109-B-D-1, 38 ISLAND AVENUE, CLIFF ISLAND

September 29, 1983

Your application to construct a set of stairs at Cliff Island Library has been reviewed and a building permit is herewith issued subject to the following requirement:

LOT PLAN SHOWING  
STEPS BRIDGE ADDED TO  
CLIFF ISLAND LIBRARY

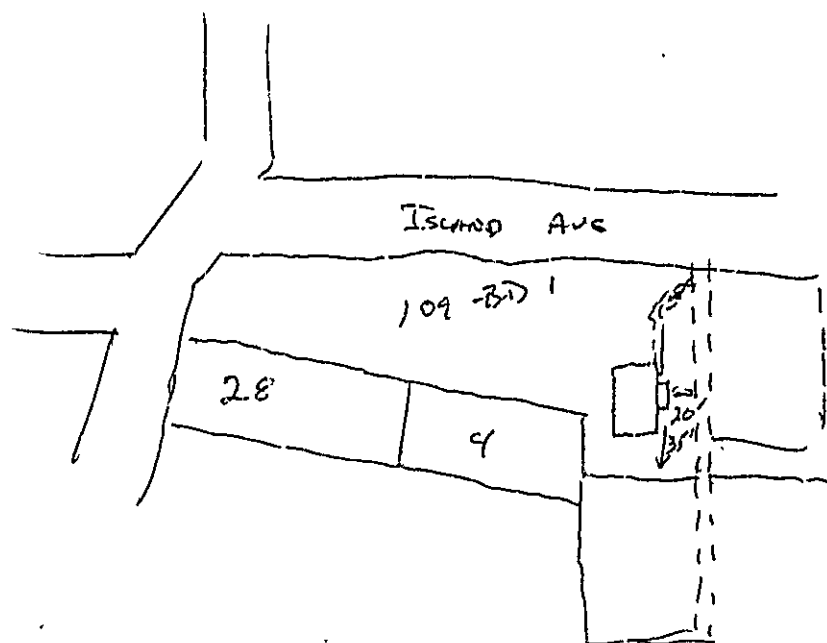
The maximum riser shall be 7 inches minimum riser 4".
Minimum tread 11 inches.
